NATIONAL GRID ELECTRICITY TRANSMISSION PLC

Response to Promoters Change Report on behalf of National Grid Electricity Transmission Plc

Comments on Change Report – Section 2.2.7

Title: 2.4 Works plan (onshore) (sheet 41 of 42) (January 2019 Revision)

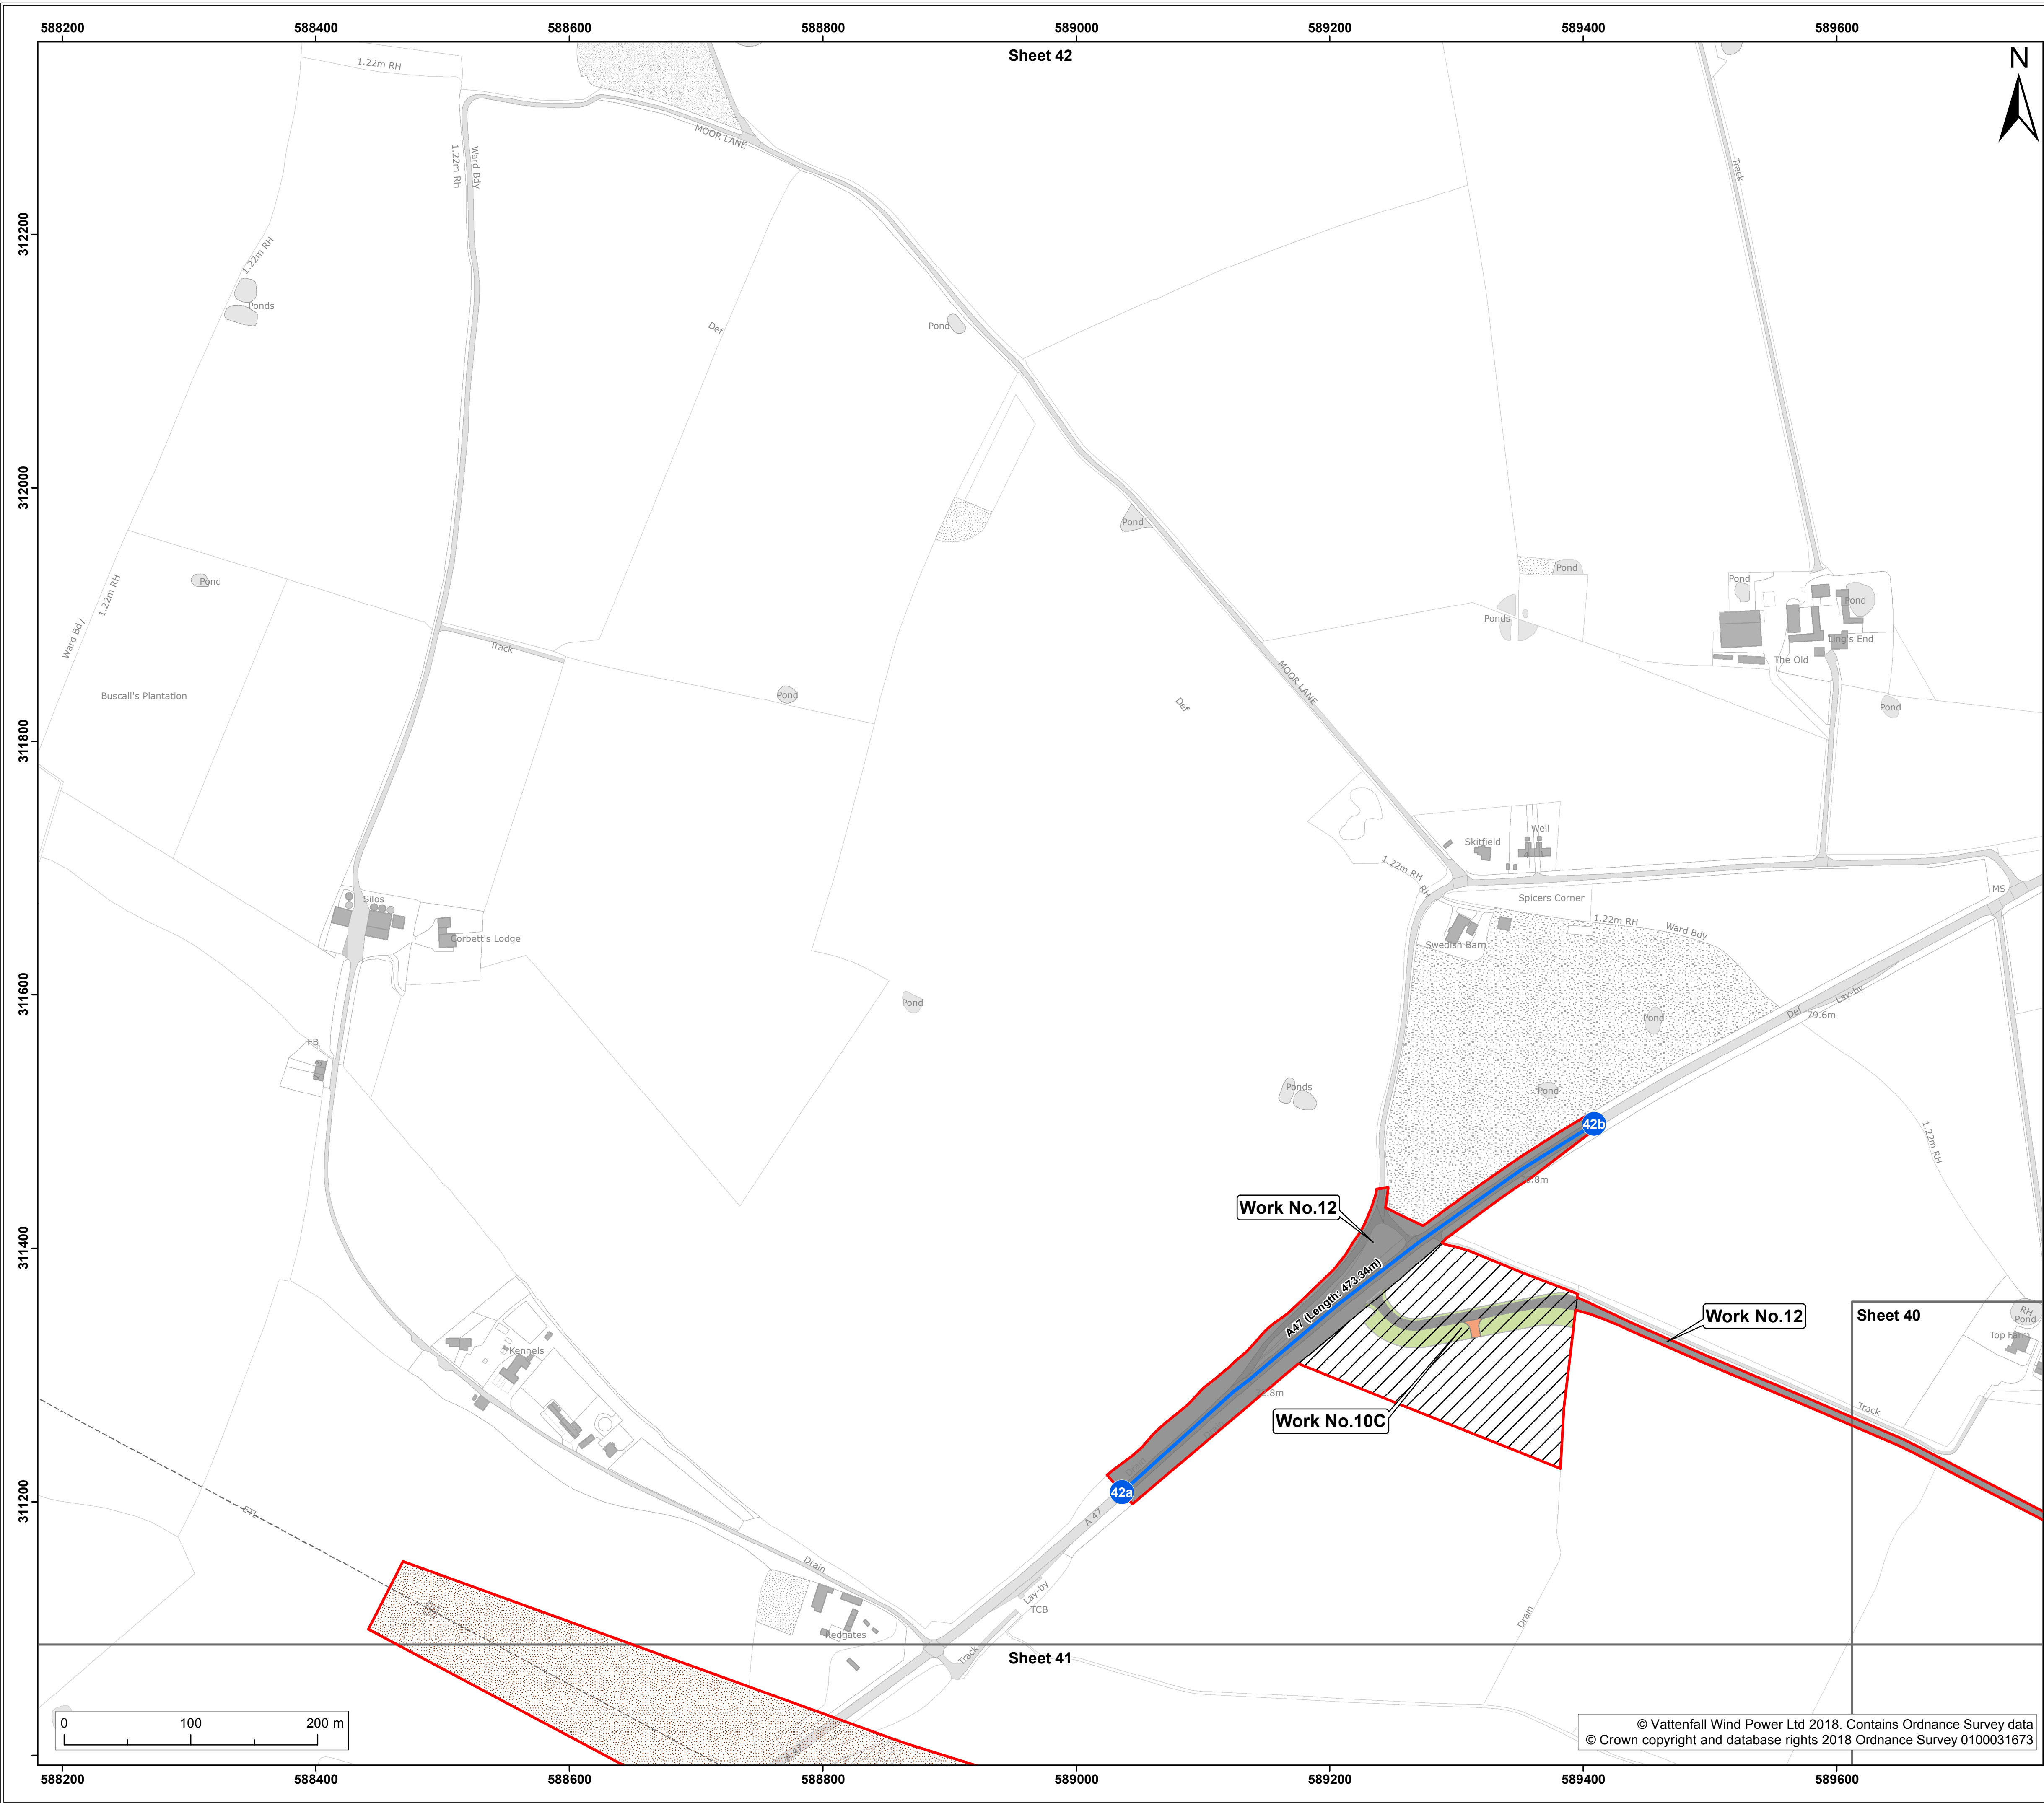
Figure 8		As a consequence of National Grid's request above the extent of land shown for acquisition of permanent rights on Land Plan Sheet 41 to allow for the Overhead lines should be extended for the full extent of the affected land owners' interest.
Figure 7		National Grid note that Works plan (onshore) (sheet 41 of 42) (December 2018 Revision) Rev 08, is the correct Work Plan showing the above amendments approved by National Grid, rather than those contained within the Change Report. The Rev 08 Work Plan shows dotted lines to demarcate the lateral limits of deviation along the width of the land now allocated in yellow for Acquisition of Permanent New Rights (Land Plan Sheet 41, Rev 03 (page 53 of the Change Report)). We understand that the Applicant is submitting a revised draft DCO at Deadline 2 with amended wording at Article 4 to allow for this limit of deviation, together with updated Works Plans and Land Plans.
